New Primary School at Warnervale for SSD Application

Strategic Design (Pre-Construction) Road Safety Audit

12 December 2019

CLIENT  
DEPARTMENT OF EDUCATION  
DRAWING TITLE:  
GENERAL ARRANGEMENT -  
MAIN SCHOOL ENTRY

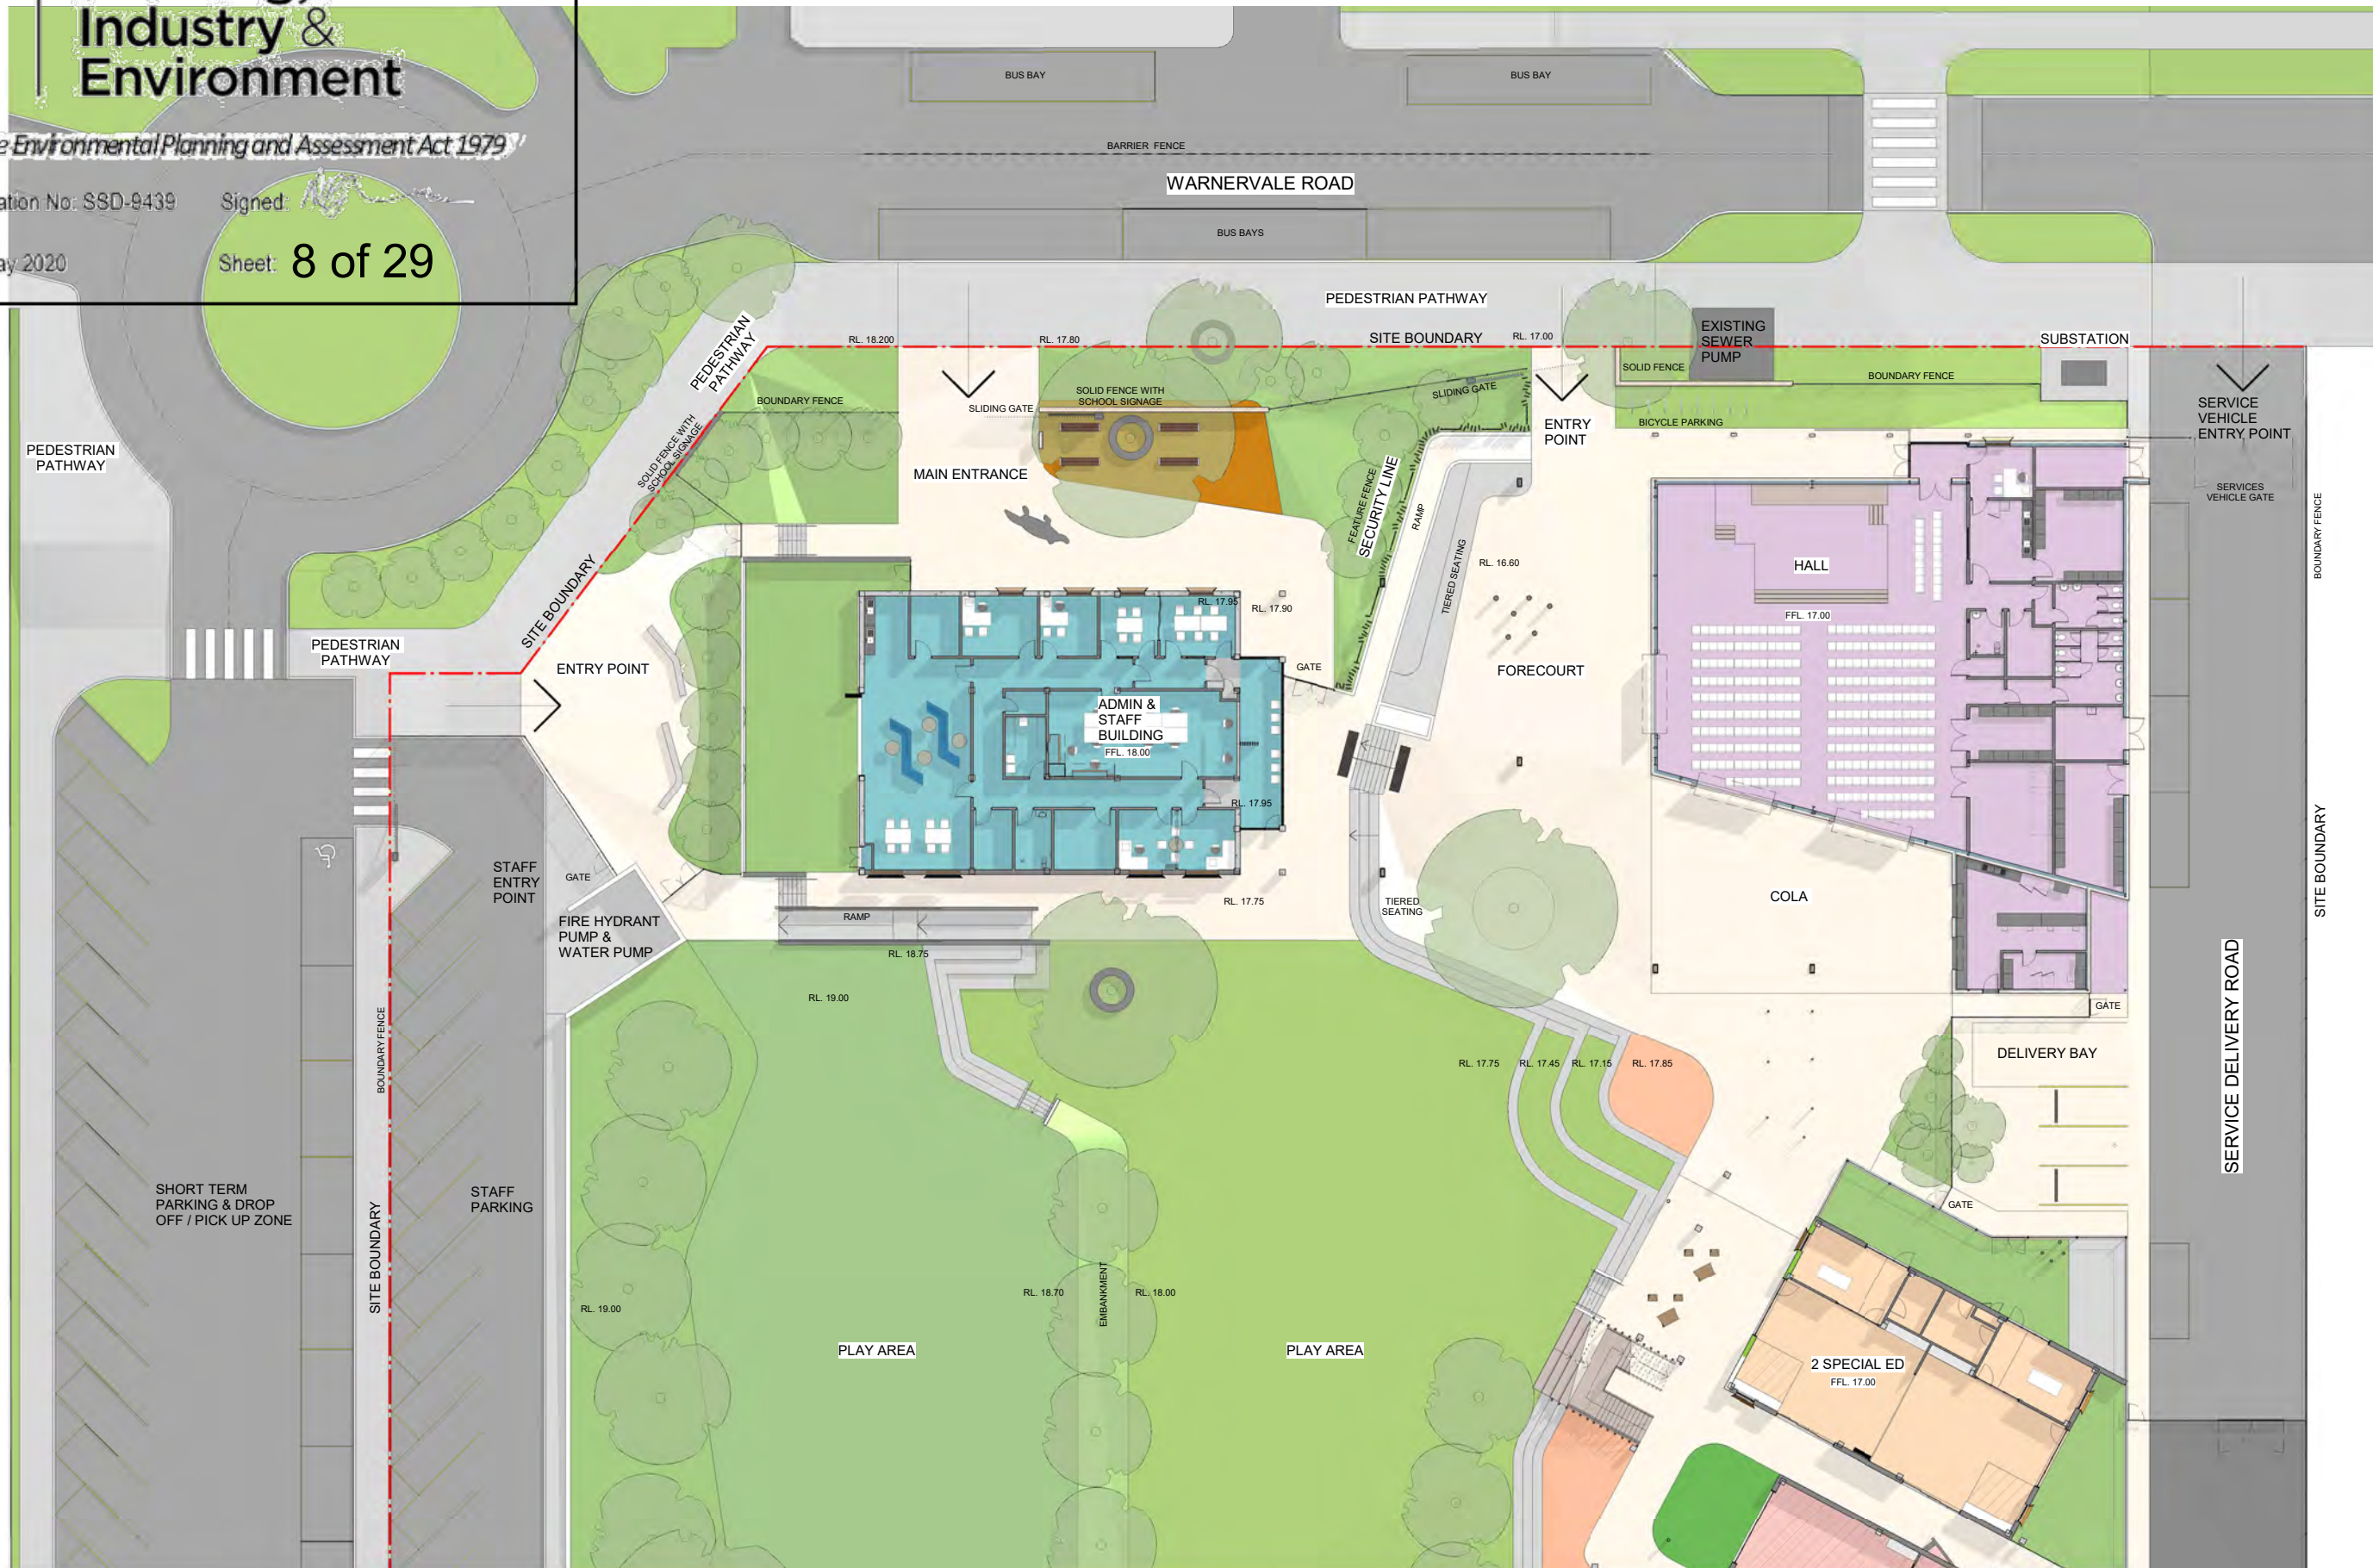
| Item No. | Location | Descriptions of Findings | Design | Likelihood | Severity | Risk Rating | Designer Response |
|----------|--|---|--|------------|----------|-------------|-------------------|
| 1. | Proposed roundabout on Warnervale Road | <p>The proposed roundabout is located on a crest. Motorists' sight lines may be compromised and hence not expecting a roundabout on Warnervale Road.</p> <p>Furthermore, the design does not include a splitter island on any approaches to the roundabout to enhance visibility to the roundabout and deflect vehicles to curve around the roundabout island.</p> <p>Risk of motorists travelling straight through the roundabout island resulting in conflicts with other vehicles.</p> |  <p>Diagram above: strategic design of the roundabout</p>  <p>Photo above: Eastbound approach to the proposed roundabout location</p>  <p>Photo above: Westbound approach to the proposed roundabout location</p> | Occasional | Moderate | Medium | |

| Item No. | Location | Descriptions of Findings | Design | Likelihood | Severity | Risk Rating | Designer Response |
|----------|---|--|---|------------|----------|-------------|-------------------|
| 2. | Proposed pedestrian crossing on Warnervale Road | <p>It is not clear whether lighting would be provided directly above the proposed pedestrian crossing on Warnervale Road.</p> <p>Insufficient level of illumination at a pedestrian crossing increases risks to pedestrians as motorists may not sight the crossing facility and the pedestrians on it during the night-time.</p> |  | Improbable | Major | Medium | |
| 3 | Proposed roundabout on Warnervale Road | <p>Warnervale Road on approach to the new roundabout comprises one travel lane. The new roundabout on Warnervale Road comprises two circulating lanes.</p> <p>Provision of two circulating lanes through the roundabout is unnecessary and may lead to lane change movements and motorists not reducing their travel speed whilst on the roundabout.</p> |  | Improbable | Major | Medium | |

| Item No. | Location | Descriptions of Findings | Design | Likelihood | Severity | Risk Rating | Designer Response |
|----------|---|--|---|------------|----------|-------------|-------------------|
| 4. | Proposed pedestrian crossing on Warnervale Road | <p>The proposed pedestrian crossing on Warnervale Road is located away from the main school entrance.</p> <p>Consequently, students alighting a bus at the westernmost bus stop on the north side of Warnervale Road may not use the proposed pedestrian crossing and may take the shortest route across Warnervale Road which may lead to incidents with vehicles on Warnervale Road.</p> |  | Improbable | Moderate | Low | |
| 5. | No. 50 Warnervale Road driveway | <p>The distance between the existing driveway of No. 50 Warnervale Road and the roundabout is approximately 3m which is less than the minimum requirement of 6m according to AS2890.1.</p> <p>In addition, there are no physical measures to prevent vehicles turning right into and out of the driveway adjacent to the roundabout.</p> <p>Risk of a vehicle entering the roundabout circulation lane directly from the No. 50 Warnervale Road driveway. This would increase traffic conflicts at the roundabout.</p> |  | Improbable | Moderate | Low | |

| Item No. | Location | Descriptions of Findings | Design | Likelihood | Severity | Risk Rating | Designer Response |
|----------|---------------------------------------|--|---|------------|----------|-------------|-------------------|
| 6. | Proposed bus zones on Warnervale Road | <p>The bus zone on the south side of Warnervale Road appears to be 45m to accommodate three buses. This is insufficient to enable a bus to manoeuvre into the third bus bay, and a bus to leave the second and third bus bay, when other bus bays are occupied.</p> <p>Furthermore, the length of the first bus zone on the north side of Warnervale Road is insufficient to enable a bus to draw out due to the kerb build out.</p> |  | - | - | Note only | |

| Item No. | Location | Descriptions of Findings | Design | Likelihood | Severity | Risk Rating | Designer Response |
|----------|---|--|---|------------|----------|-------------|-------------------|
| 8. | Proposed pedestrian crossing on Warnervale Road | The proposed pedestrian crossing may not meet the numerical warrant given the low pedestrian volumes across Warnervale Road. |  | - | - | Note only | |

| Item No. | Location | Descriptions of Findings | Design | Likelihood | Severity | Risk Rating | Designer Response |
|----------|---------------------------------|---|---|------------|----------|-------------|-------------------|
| 9. | Travel lanes on Warnervale Road | The width of the travel lane on Warnervale Road appears to be 3.1m which is less than the minimum requirement of 3.25m for a bus route. |  | - | - | Note only | |
